Geotechnical engineer to review design drawings and provide in a letter format that the drawings were reviewed and were found to be in accordance with their geotechnical recommendations or provide recommendations for design revisions. In said letter include risk statement in accordance with MICC 19.07.160.

We were provided with the revised set of architectural (Brandt Design Group), civil (LPD Engineering), and structural (SSF Engineers) plans dated 4/30/2021 for review of the geotechnical aspects of the design.

**SH2.1**

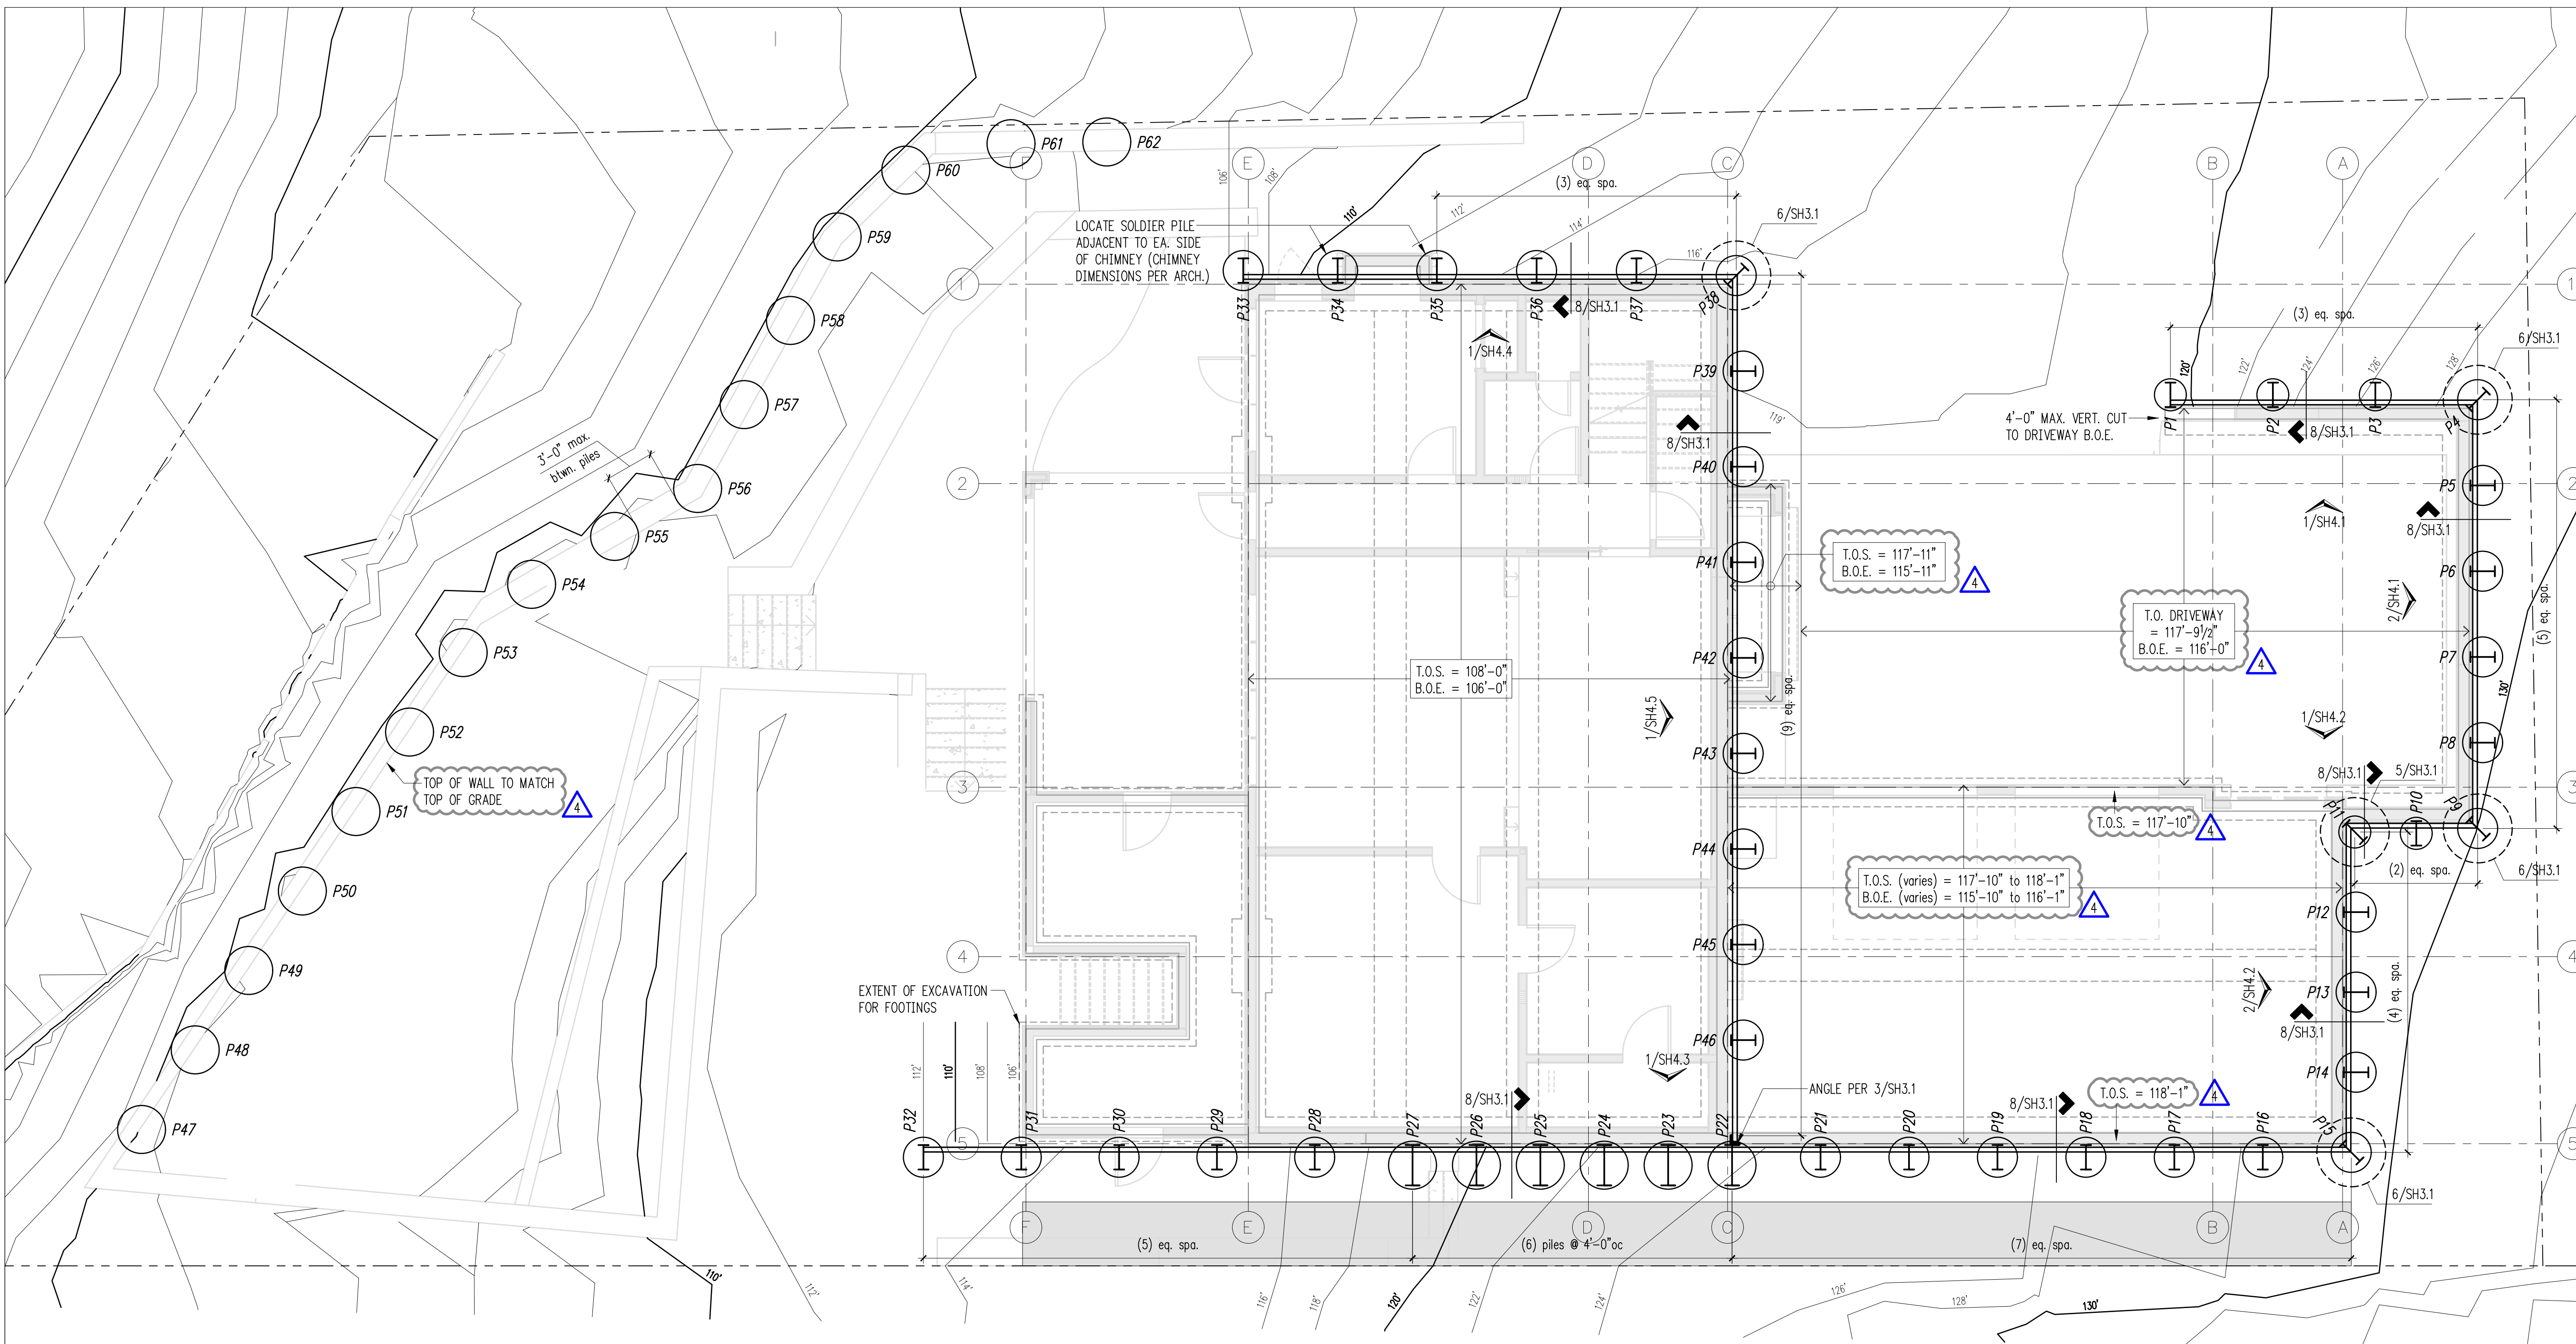
The extent of the stabilization piles has been clearly delineated on revised sheet SH2.1 date 4/30/2021. This includes piles P29-P44. The minimum embedment of the piles to 28 feet below elevation 89 conforms with our recommendations.
